RE: Crosslin Accessory Dwelling Unit, AU-11-00003

The application for an Administrative Use Permit on Assessors Map Number Parcel 17-20-20000-0014, you submitted on July 21, 2011, has undergone preliminary review by Kittitas County Community Development Services staff and has been deemed complete for initial processing as of July 26, 2011.

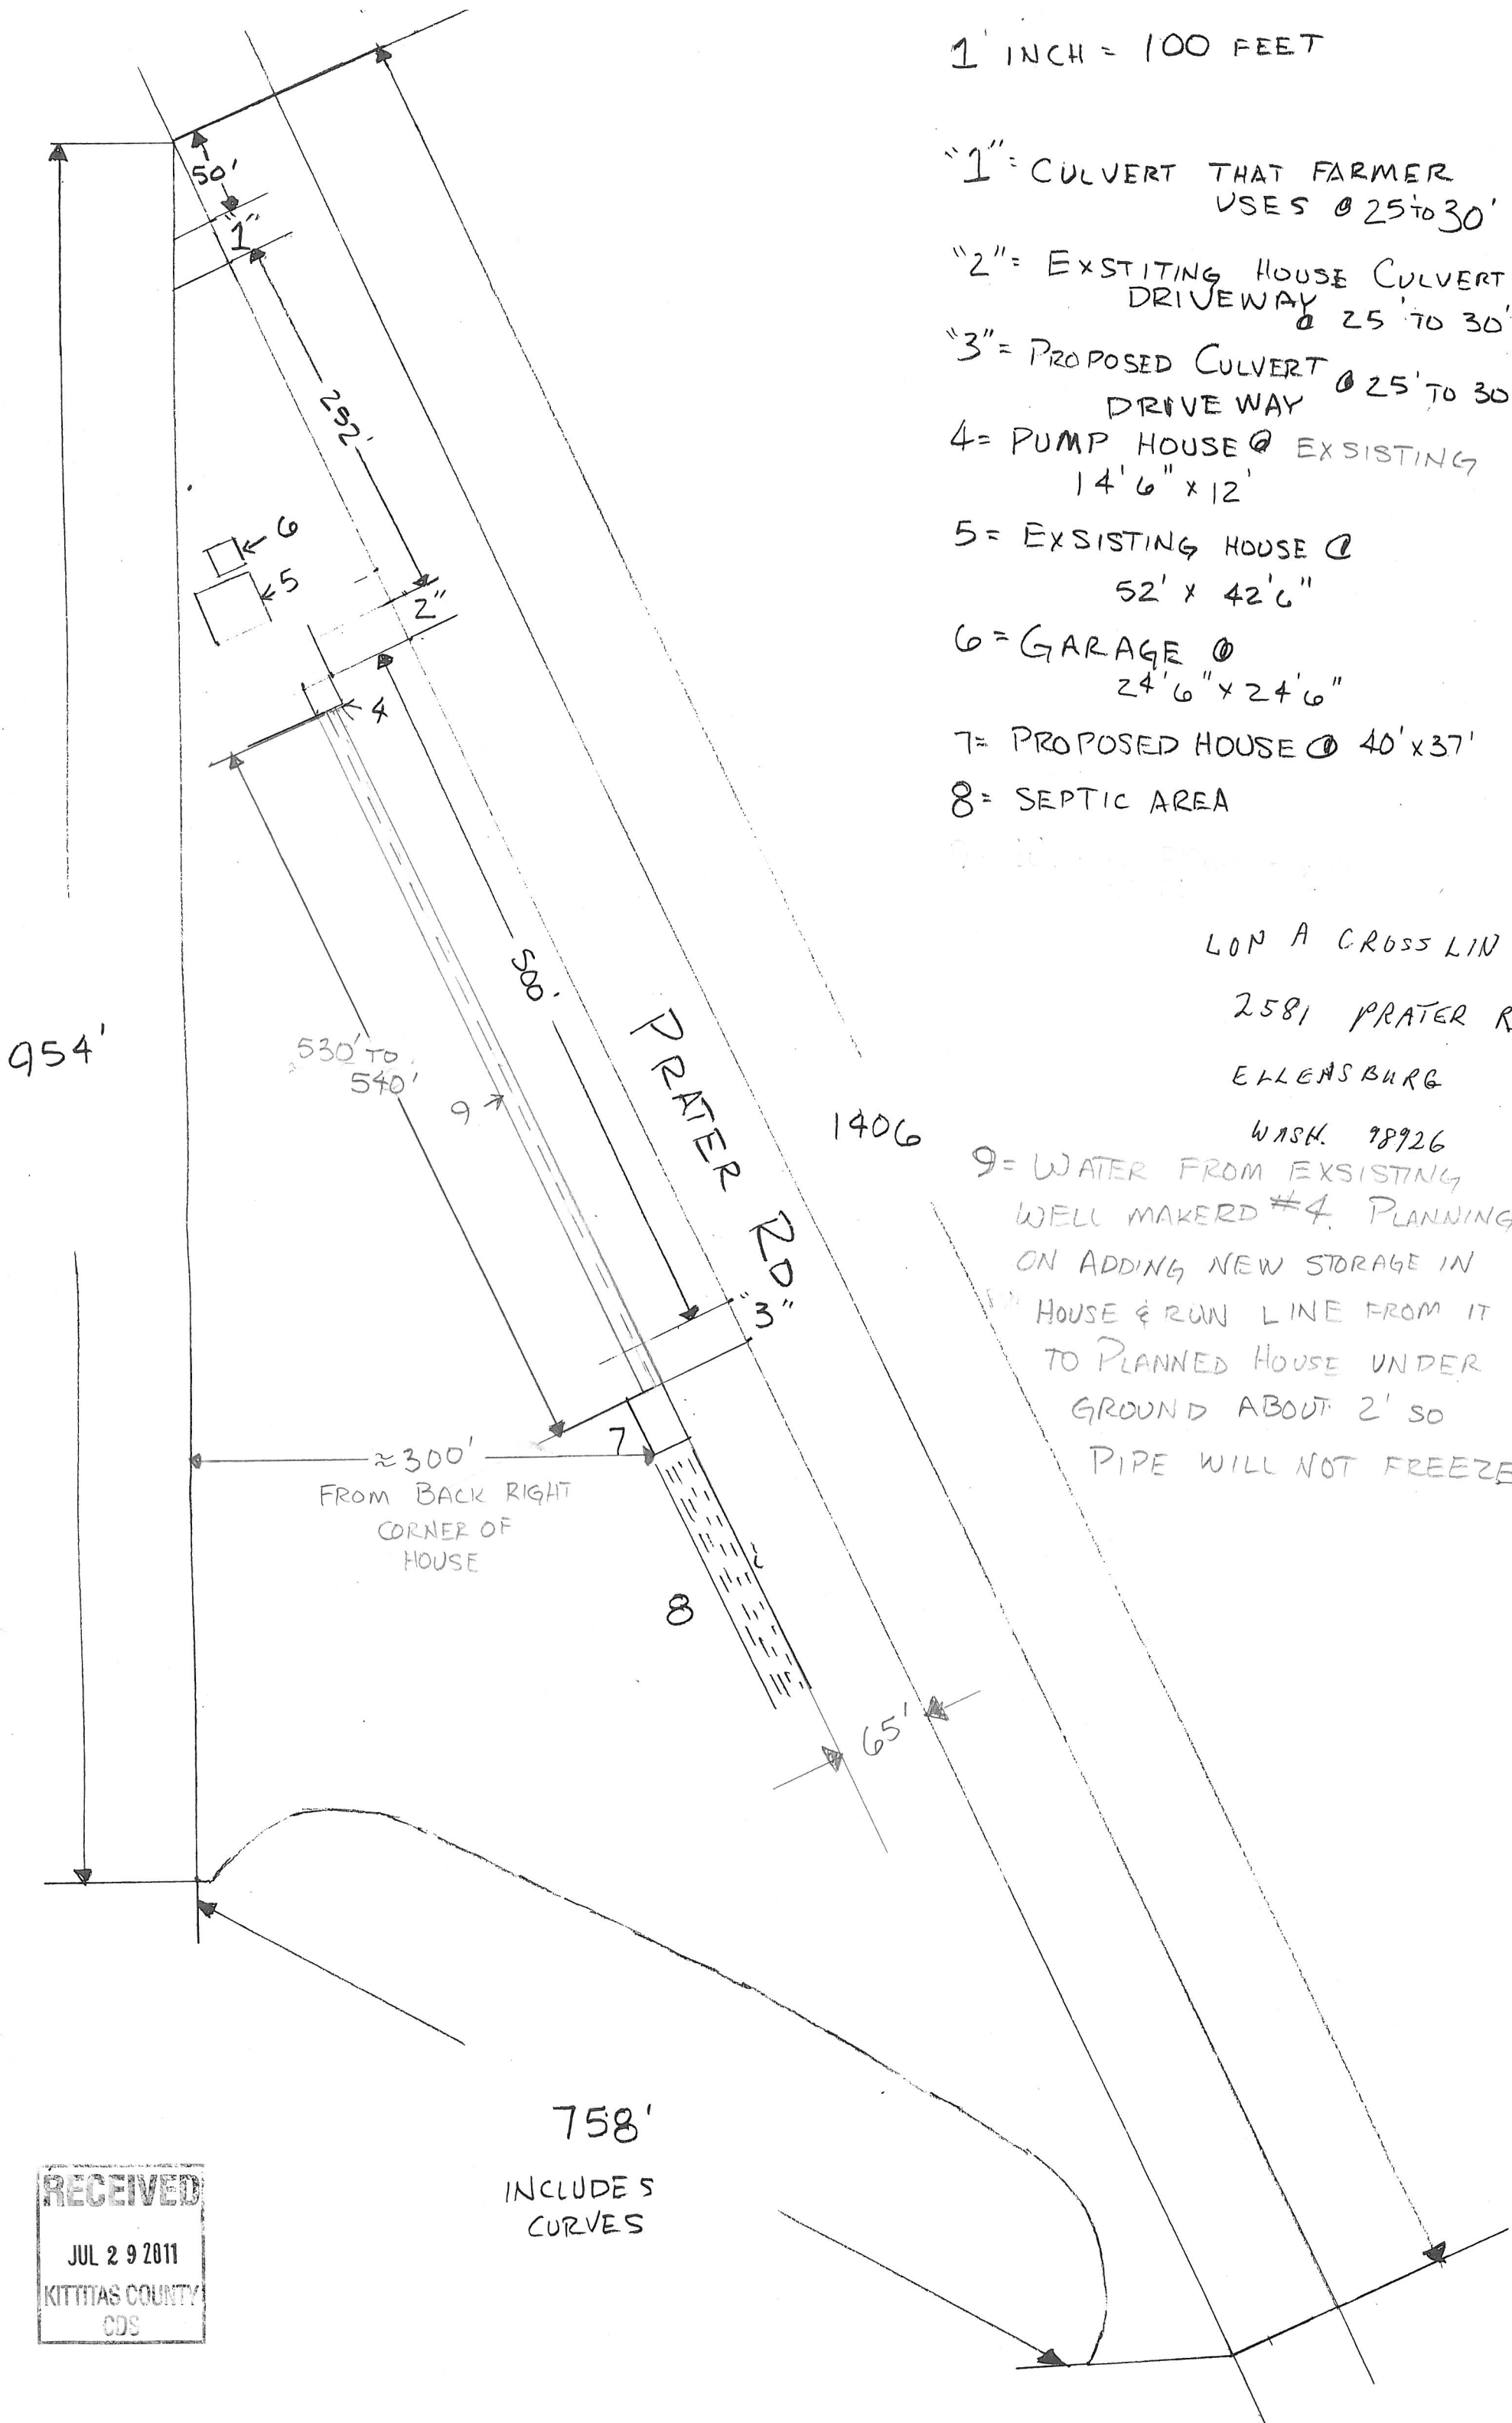
!!! PLEASE BE ADVISED THAT IN ORDER TO FULLY PROCESS YOUR APPLICATION THE SITE PLAN SUBMITTED MUST SHOW THE LOCATION OF THE EXISING WELL/WATER SYSTEM AS WELL AS SOME DESCRIPTION OF THE PROPOSED WELL/WATER SYSTEM FOR THE ACCESSORY DWELLING UNIT. !!!
